**WEST SUSSEX COUNTY COUNCIL  
STRATEGIC PLANNING CONSULTATION**

**SUBJECT: LU/328/14/PL - Construction of side extension to industrial unit**

**Unit 10, Martello Enterprise Centre, Courtwick Lane, Wick, Littlehampton,  
BN17 7PA**

Proposed Extension for RJH Construction
Unit 10 Martello Business Centre, Courtwick Lane, Littlehampton
- AS EXISTING + Proposed Roof Plan

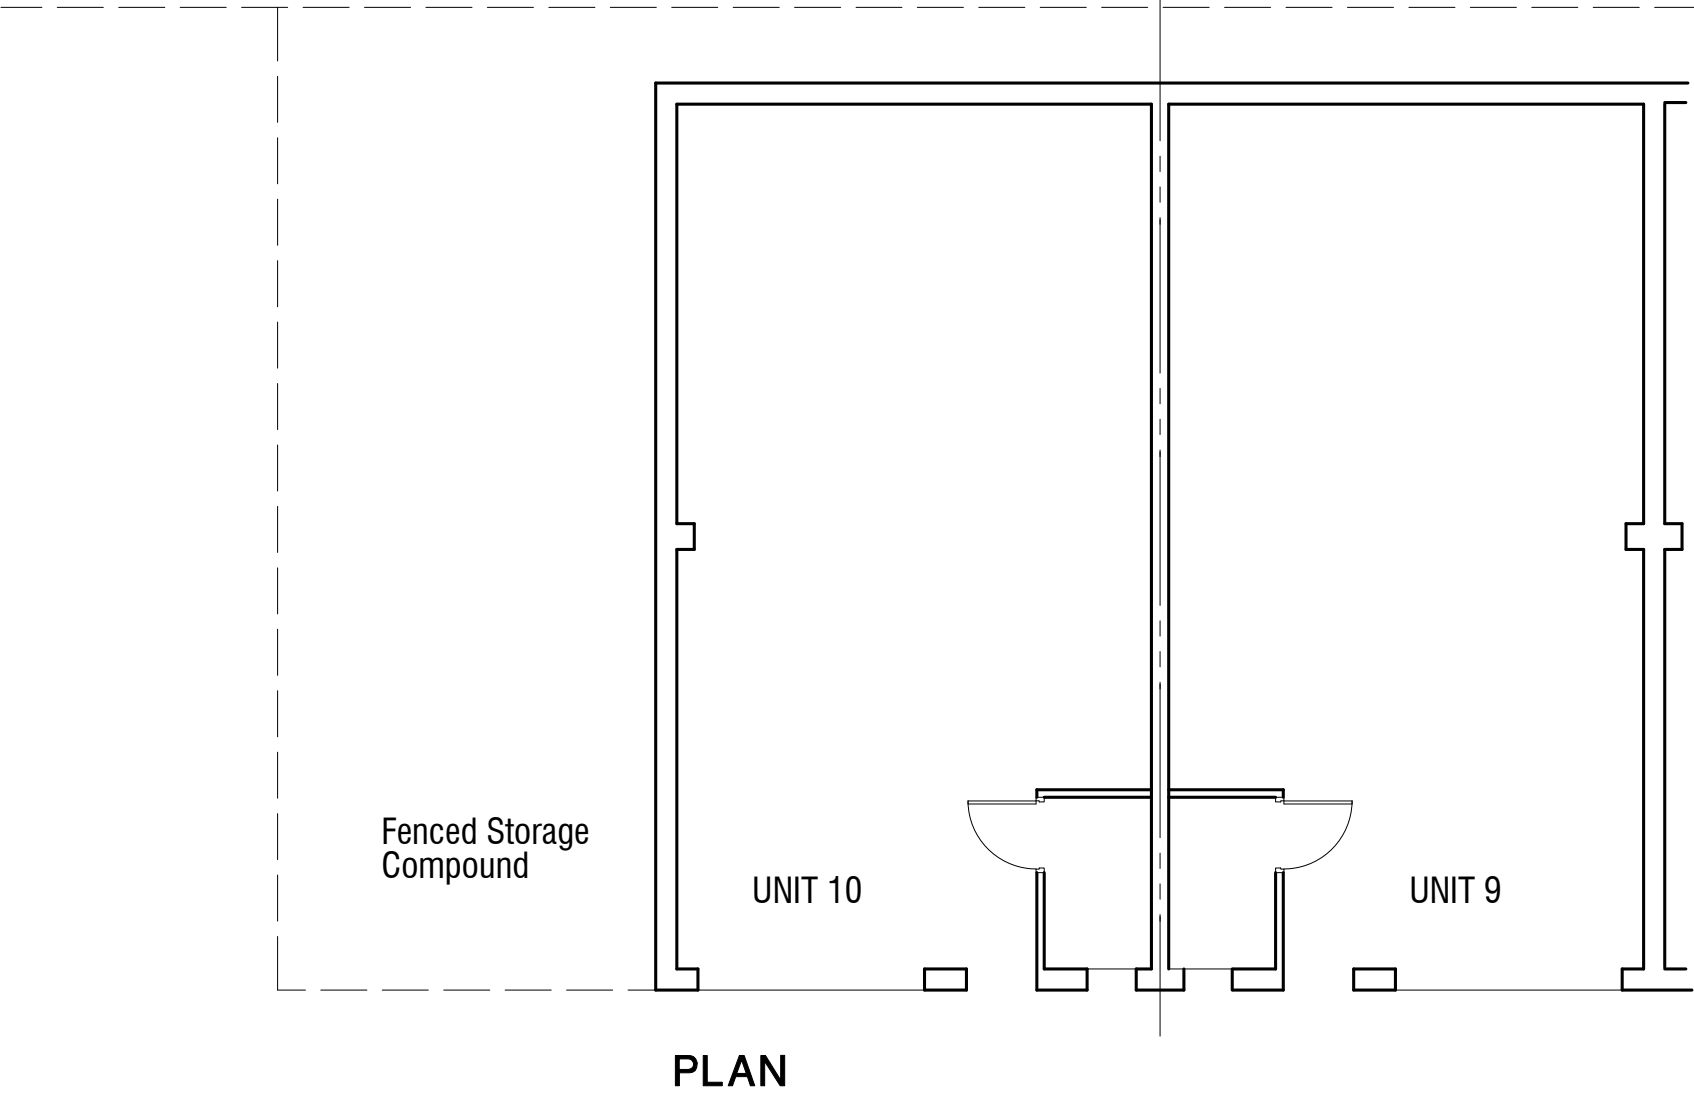
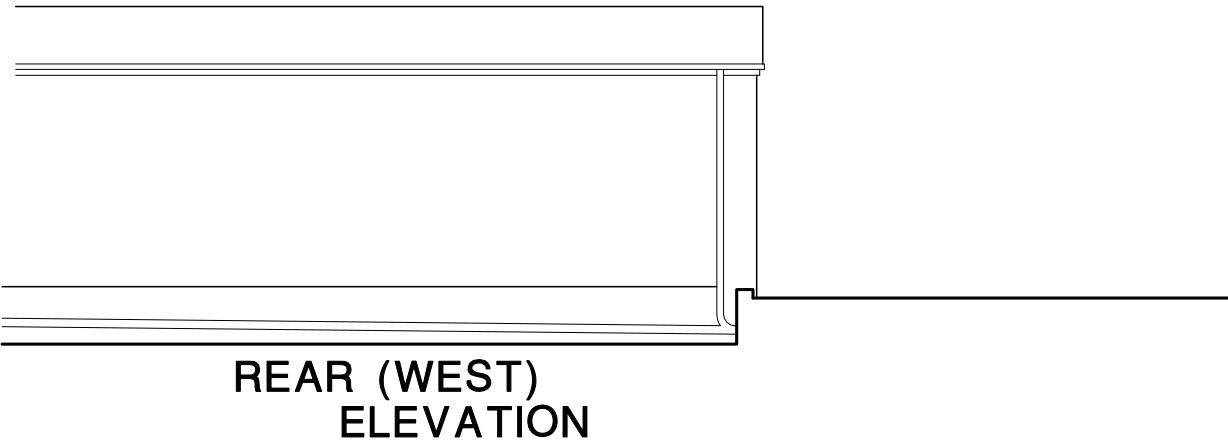
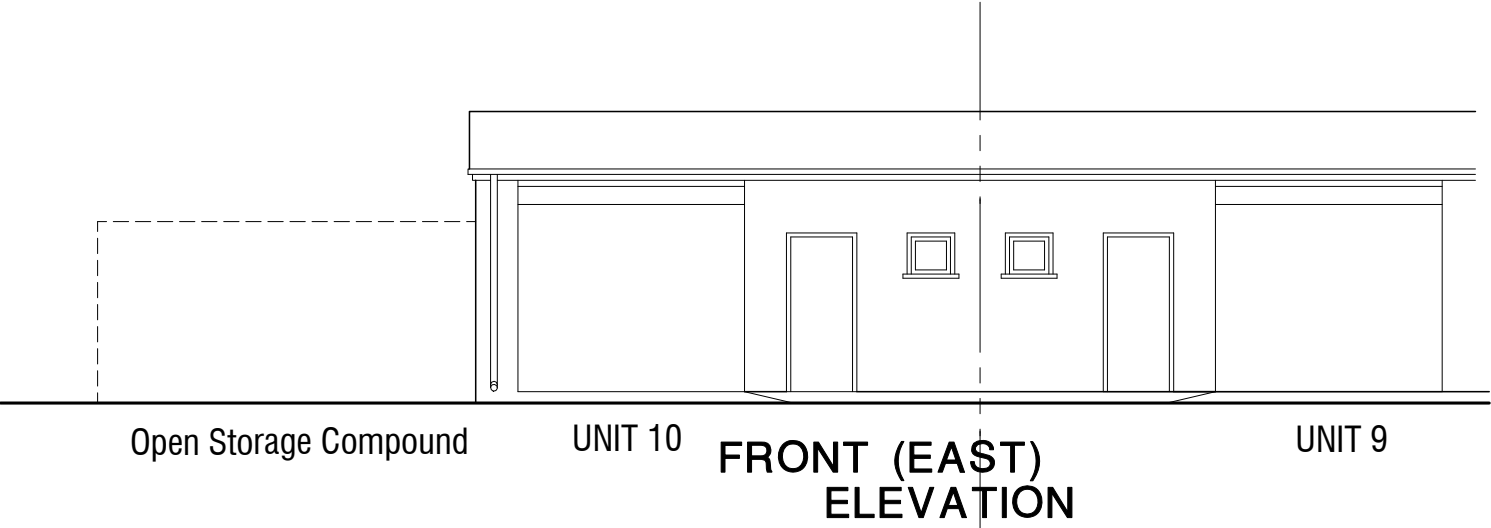
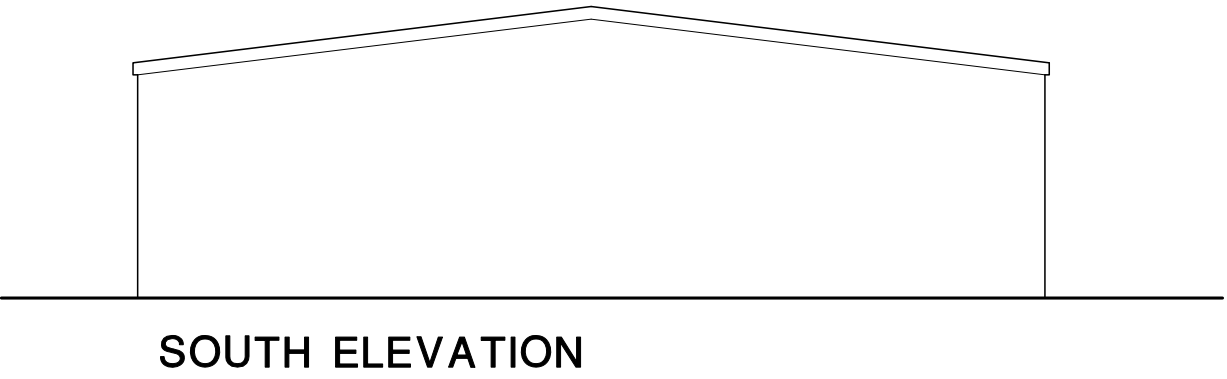
The side extension created will be 59sqm, with 1 additional car parking space. This meets WSCC maximum standards for 1 space for every 30sqm, and will cater for the additional employee. Cycle storage, which is secure and covered should be provided.
